Response to WSCC Strategic Planning Consultation Comments dated 6 September 2012

**Roundstone Lane, Angmering
Arun Planning Application A/82/12**

Barratt David Wilson Southampton

23 November 2012

NOTES:

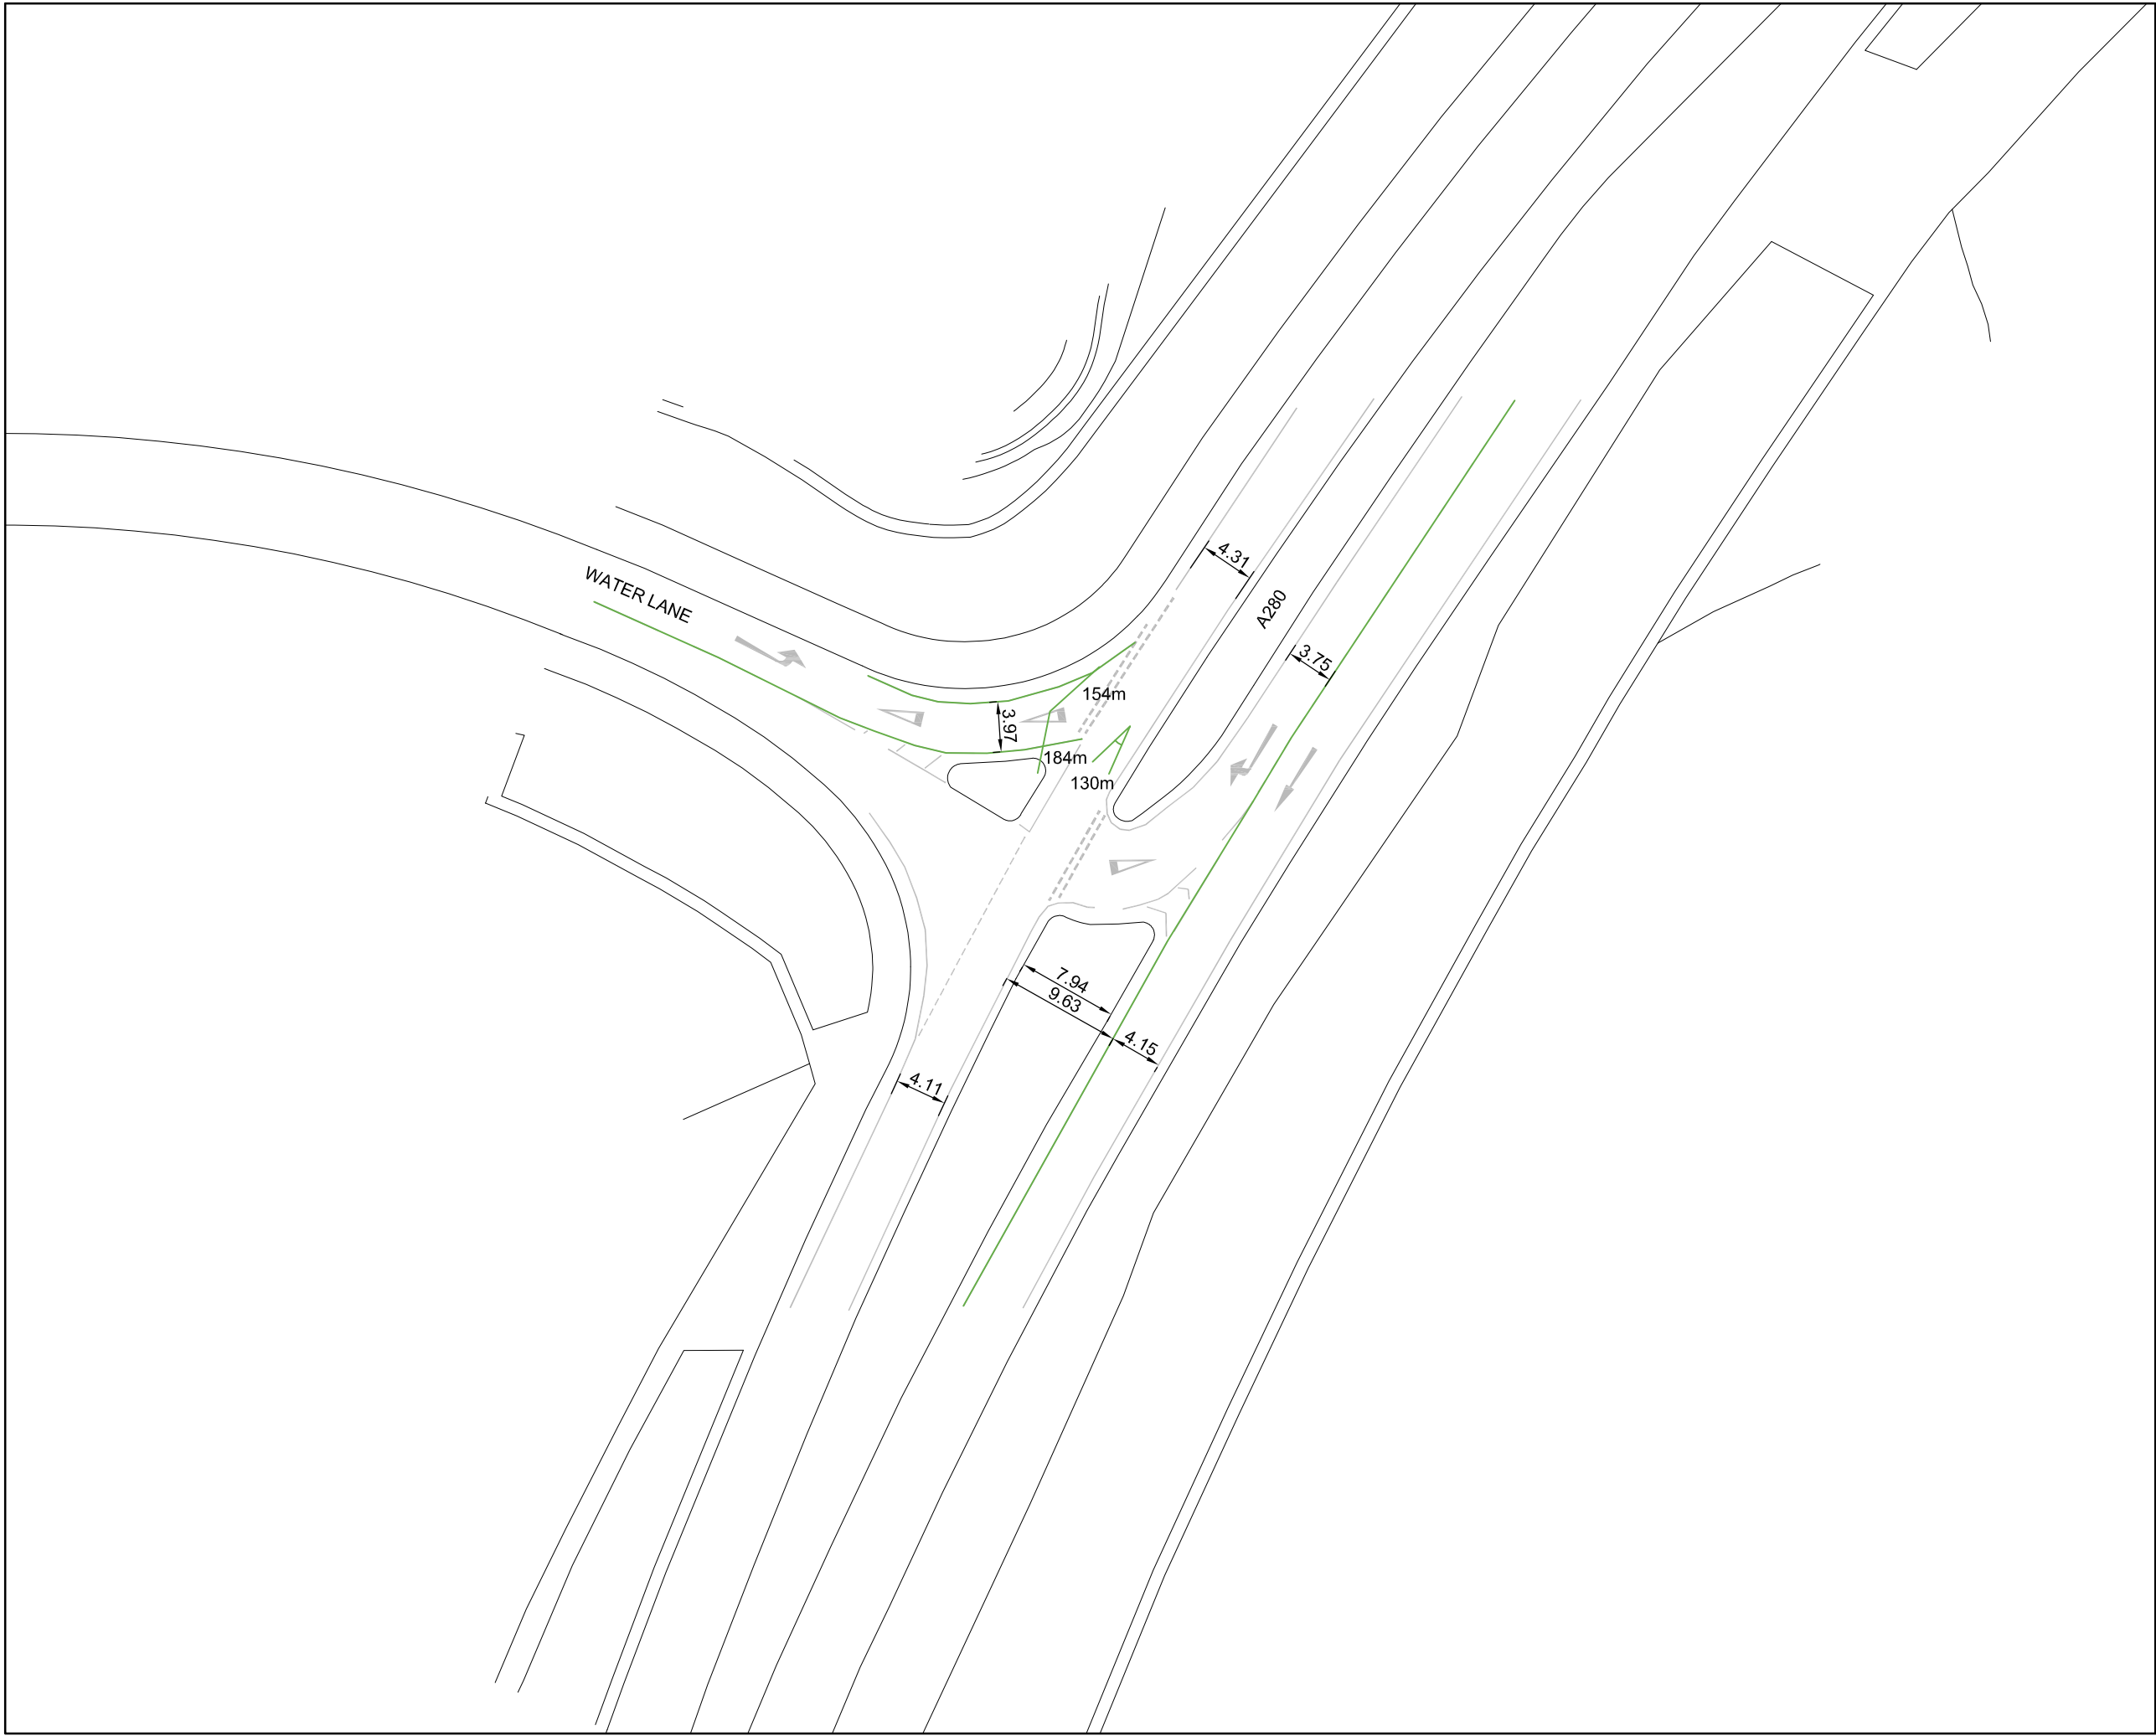
Junction assessments: These do not appear to be consistent with observed traffic conditions on the A259 or at Water Lane/A283. The queue lengths in Appendix 11 appear to be lower than actual observed queue lengths during the morning and evening peak hours. Further detail should be provided on the junction assessments relating to the A259 to explain the relationship between observed congestion and the technical junction assessments.

Queue length data taken during the traffic survey together with a summary in table and also schematic format is attached in Appendix 1 at the rear of this note.

The observed lengths in vehicles were noted every five minutes by the survey company. The summary queue lengths compiled by us from this data are mean average PCUs to match the definition of queue in TRL's ARCADY method. Capacity models are based on geometrical measurements taken from Ordnance Survey and aerial photograph. Percentage arm capacity adjustments have been undertaken where necessary such that the output from the ARCADY base model shows similar results.

We believe this industry standard approach provides adequately representative models however there are two reasons the traffic conditions observed might differ from the modelling results which are worth noting before attempting to produce more 'accurate' models:

1 – Natural variance and definition of queue. The queues reported from ARCADY are mean average static queues over time segments. This does not include slow moving traffic approaching a junction or demonstrate the maximum observable number of stopped vehicles at any particular time or any particular day. It can be seen from the raw queue length data that as expected at peak times there is a significant variance in queue length. There would also be significant daily variance not able to be incorporated into the models.

2 – Congestion from downstream delays beyond the roundabouts may have been observed which is not a capacity failing of the roundabout itself and would not be appropriate to artificially throttle the performance of the roundabout to mimic this since alteration to that roundabout would not solve the problem.

Nevertheless we believe the models represent the geometry and delay on the ground and produce a fair assessment of the likely increases in queue and delays due to development which are of course small in proportion to the small increase in traffic flow due to development.
